1 February 2021
20210201 - Gardens of Peace - Response to Written Questions
(WQ1)

Gardens of Peace Muslim Cemetery (Plot 1/8) – Response to Written questions (WQ1) in respect of Deadline 2 – M25 Junction 28 Improvement Scheme

- iii) Set out in more detail specifically why Work No.29 [APP-006] (diversion of high-pressure gas pipeline) and its timescale would detrimentally affect the future operation of the cemetery and its targeted opening date of 2022.

## Appendix 2.0 – Land Plans – Plot 1.8

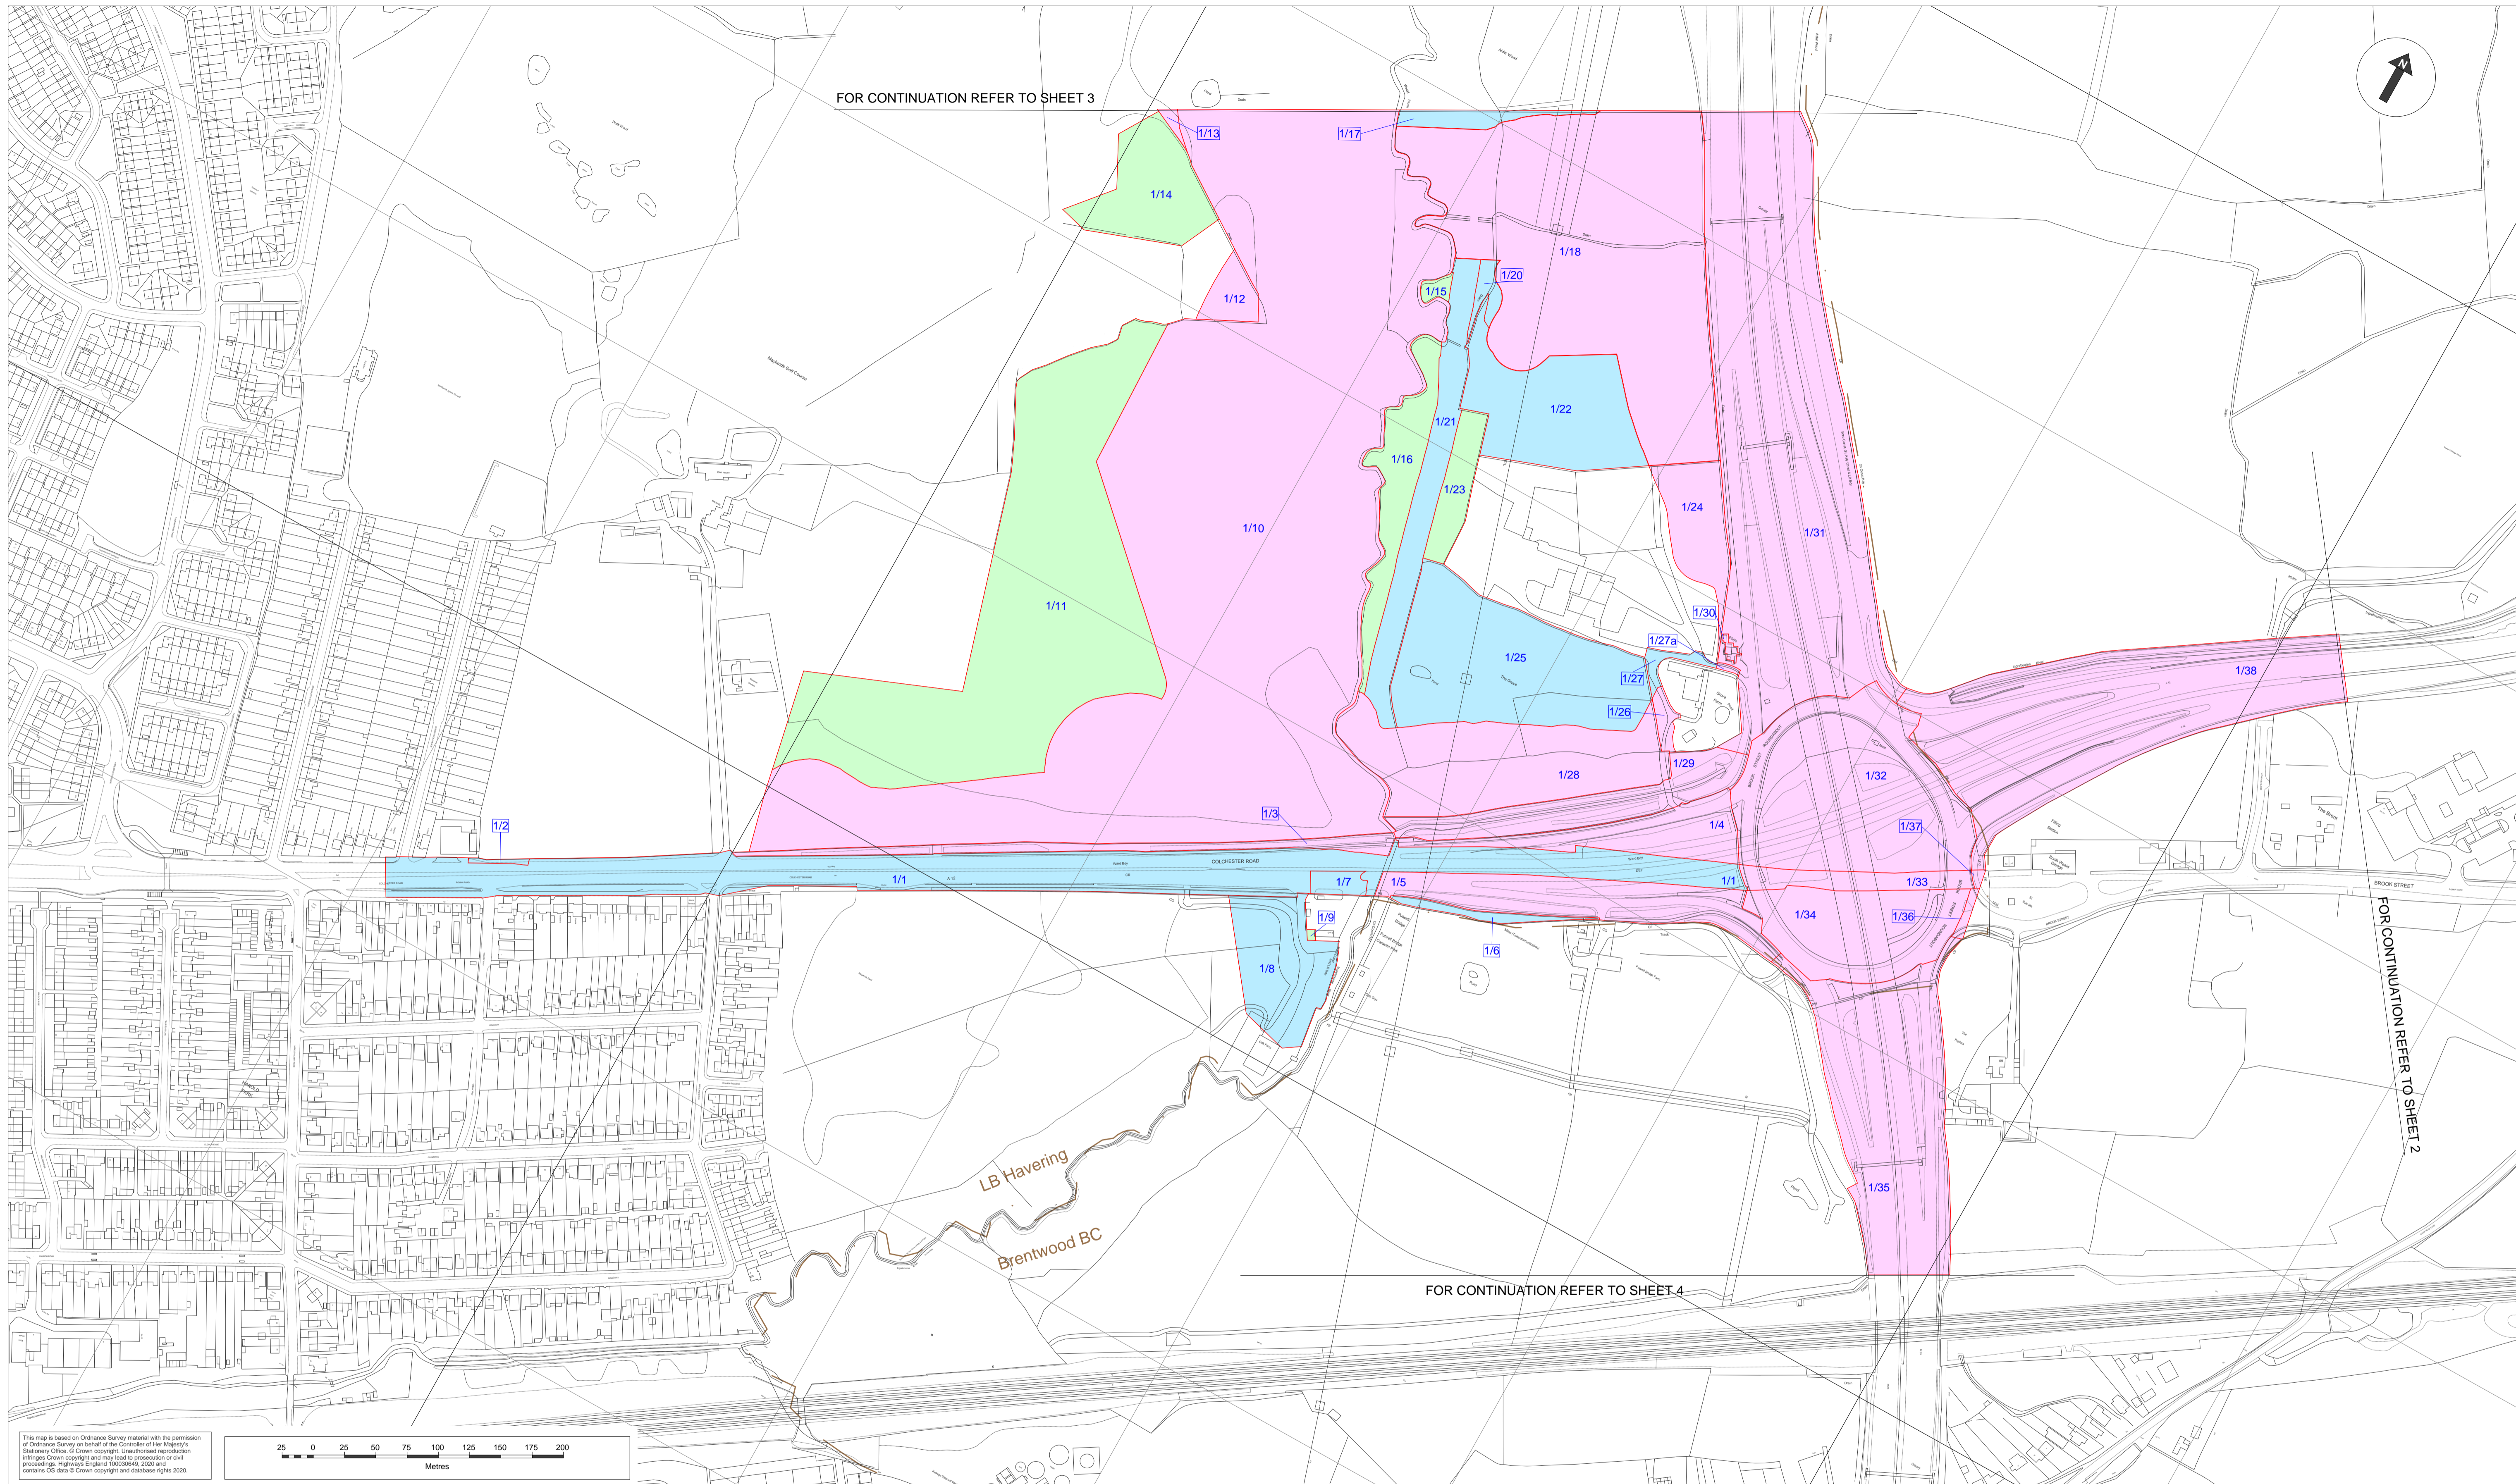
The DCO application identified Plot 1/8, as an area that will be subject to acquisition of permanent rights, thus, and as referred to later in this answer, it is assumed all land will be sterilised from its attended use, being internal road, underground services and 512 burial plots. We attach the development plan for the cemetery (see Appendix 1) and when overlaid with the Plot 1/8 boundary (Appendix 2), the severity of the gas main diversion works (Work No. 29) on Gardens of Peace development becomes evident.

As referred to above, the DCO application seeks to permanently acquire rights over Plot 1/8. Accordingly, and without knowing details on the future land use restrictions, despite requesting this from highways England in 2020, it is assumed the land will be sterilised from its intended use, being 512 burial plots, internal road and car park. Gardens of Peace however have been informed it can place and store materials directly over the gas main.

Thus, the amendments Gardens of Peace seek are a significant reduction in the boundary of Plot 1/8 to immediately reduce the effects, both temporary and permanent, on the cemetery. Gardens of Peace also seek

an amendment to the route of the gas main, to reduce the area within Plot 1/8 subject to the gas main easement, thus reducing the permanent effects on the cemetery i.e. enabling Plot 1/8 to be fully reinstated to the same order as it was prior to the gas main installation works and as proposed within the development plan (see Appendix 1).

## Appendix 4.0 – Plot 1/8 Overlay

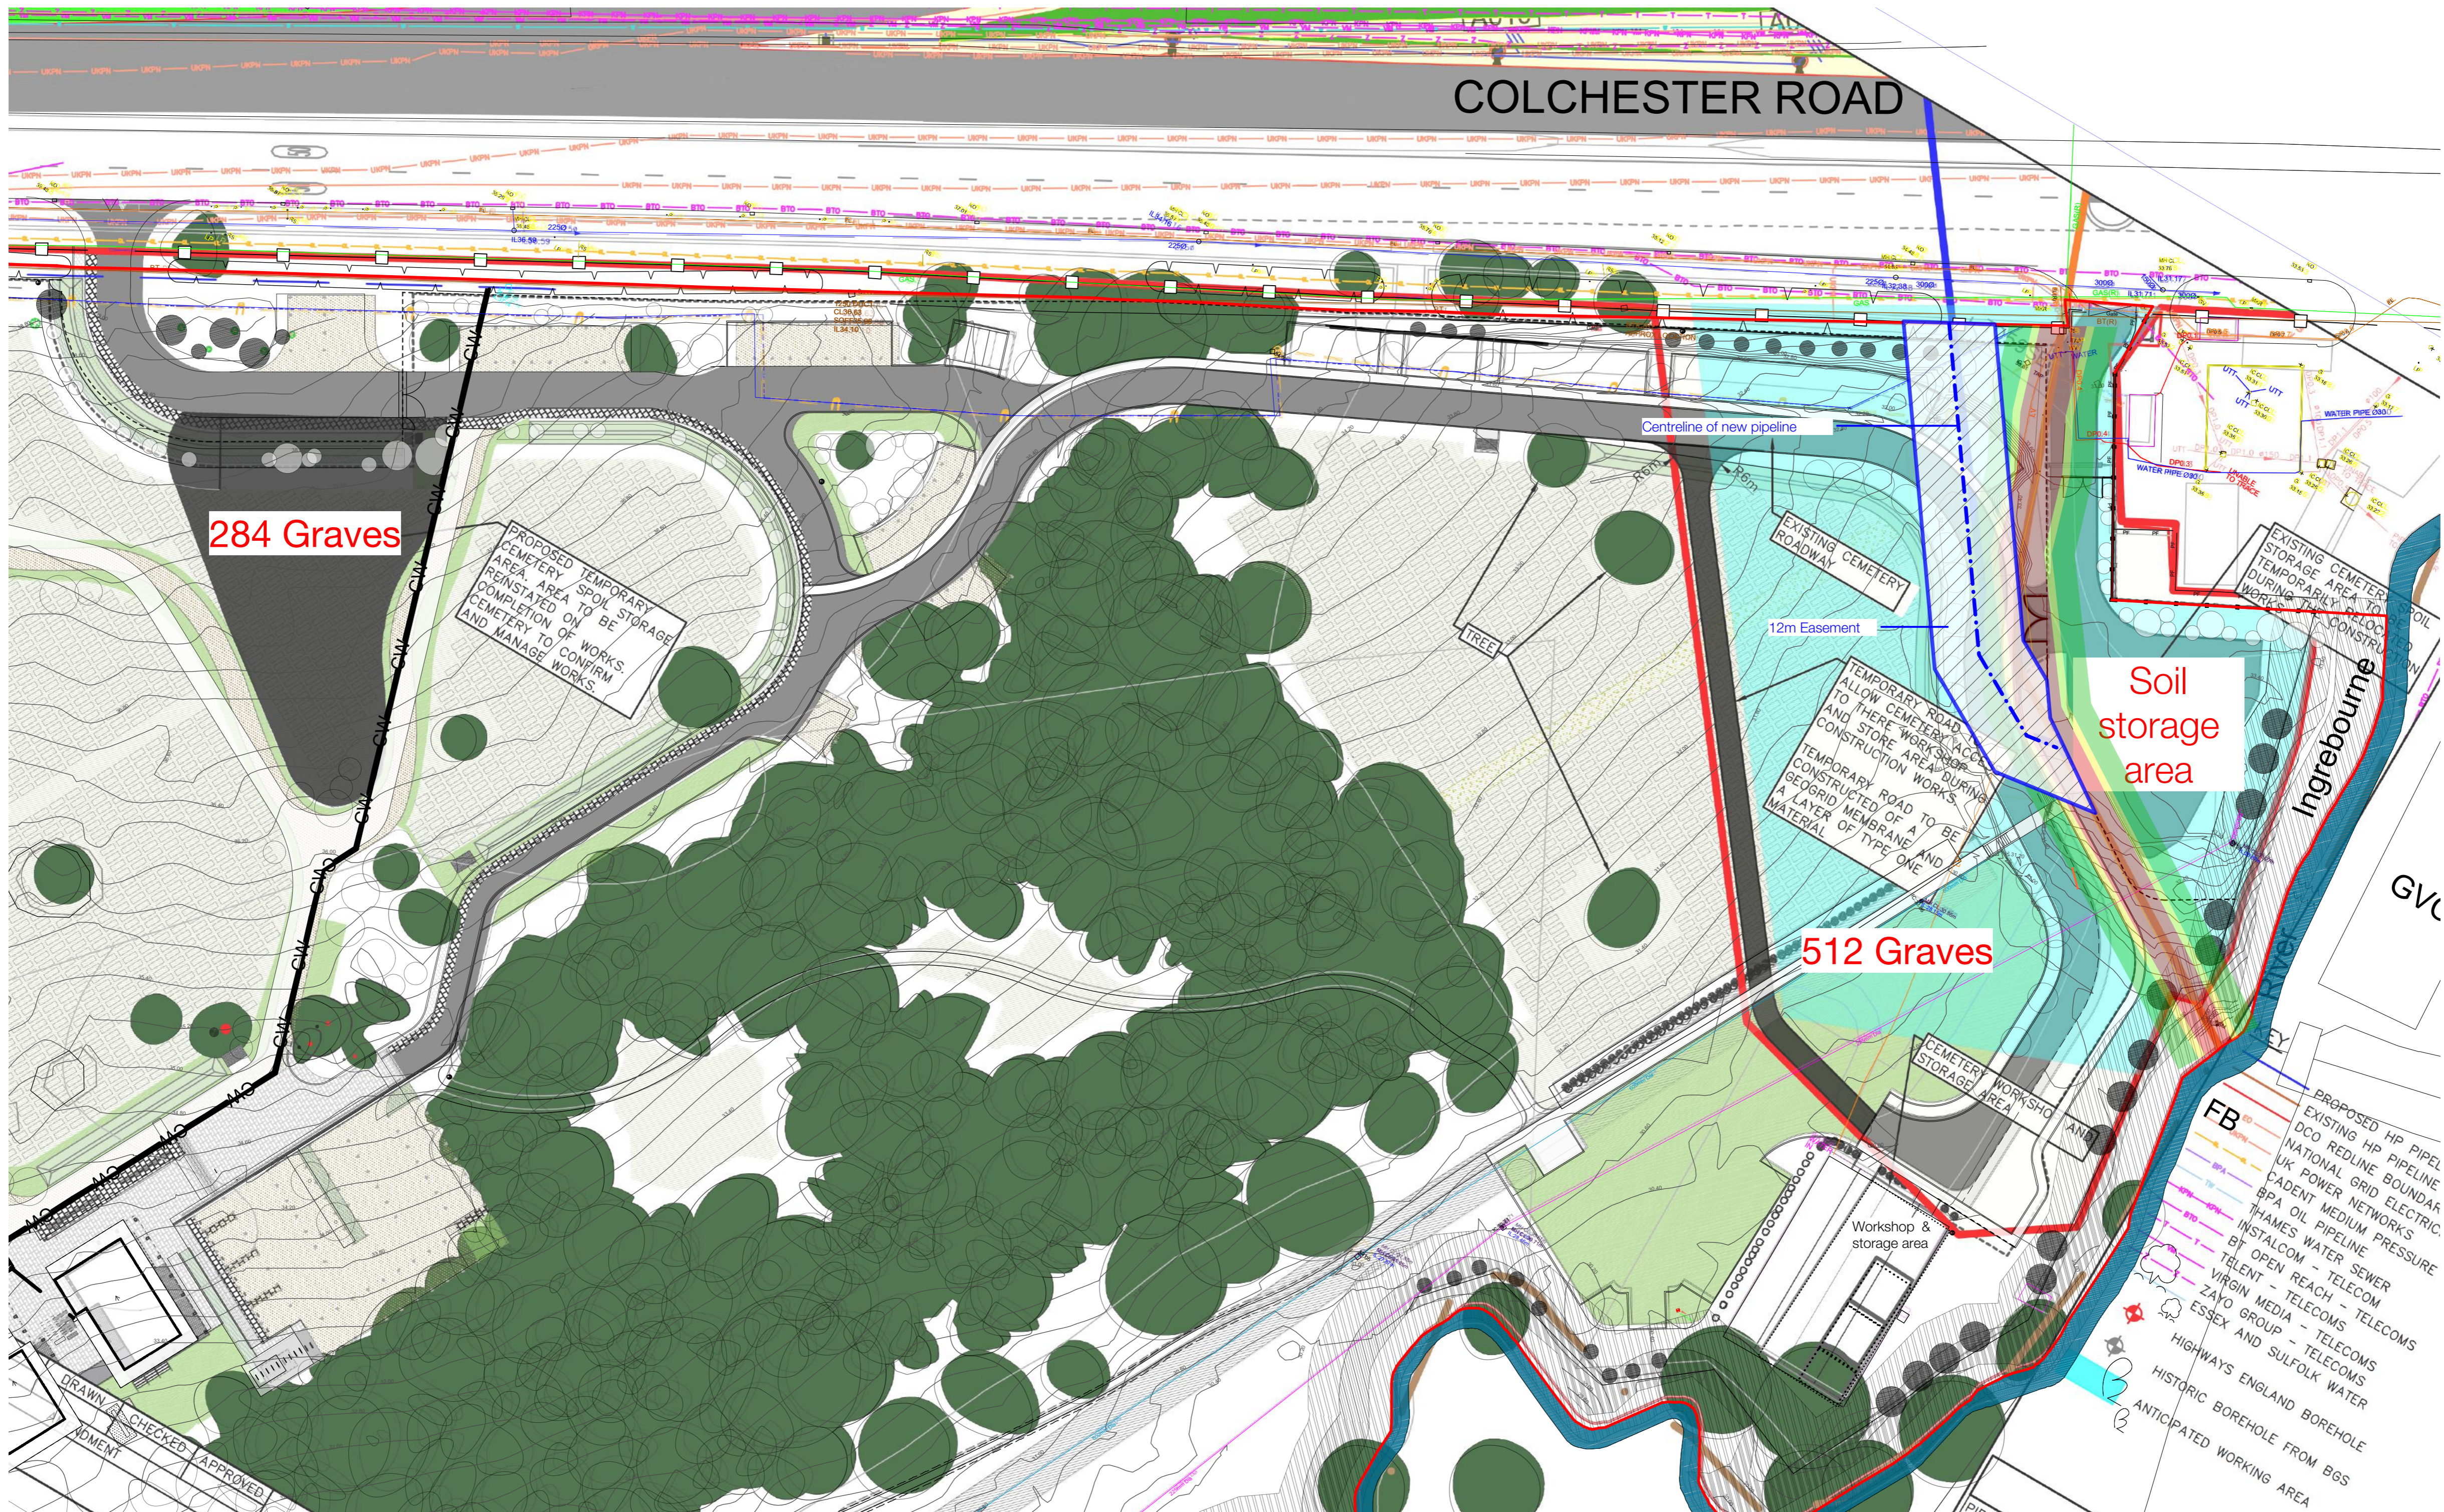
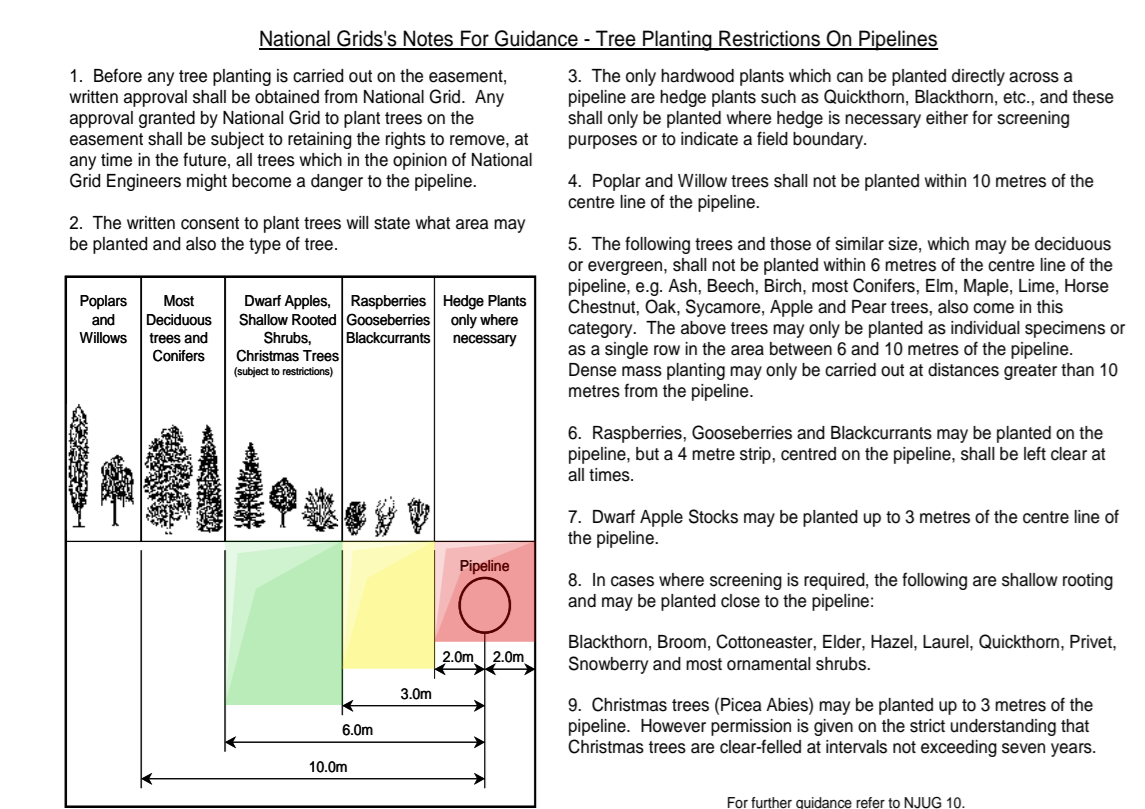
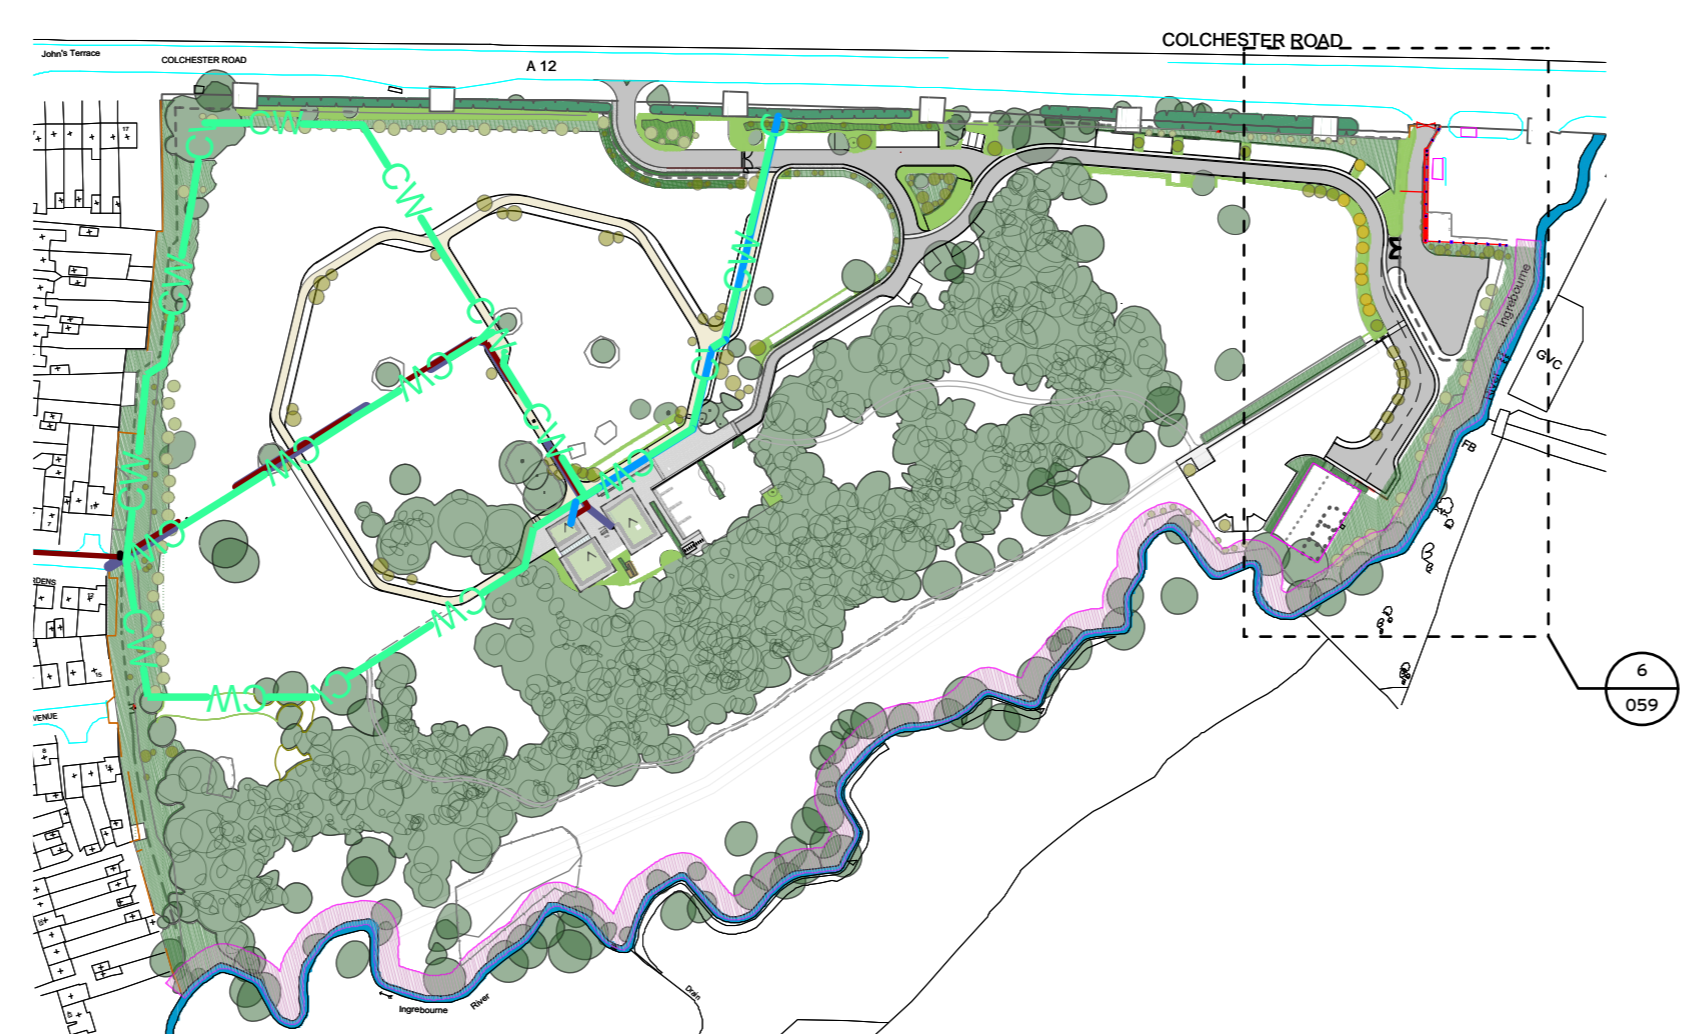
In light of that fact that the cemetery will be operational by the time the gas main works commence, utilities within Plot 1/8 will need to be relocated (see Appendix 3 – Cadent Detailed Design). These include the existing underground electrical, water and telecoms services to the workshop / store, which were installed in 2020 and

are now within the middle of the proposed gas main easement. Other services will include the drainage pipes under the internal road and associated manholes and chambers and underground lighting cables.

All services will have to be lifted and relocated to outside Plot 1/8 prior to the commencement of the gas main installation works to ensure the cemetery can continue to operate. Gardens of Peace is concerned with the effect of the temporary relocation of these services, which will need to be within land identified for burial plots, and accordingly the potential sterilisation of additional land in both the short and long term.
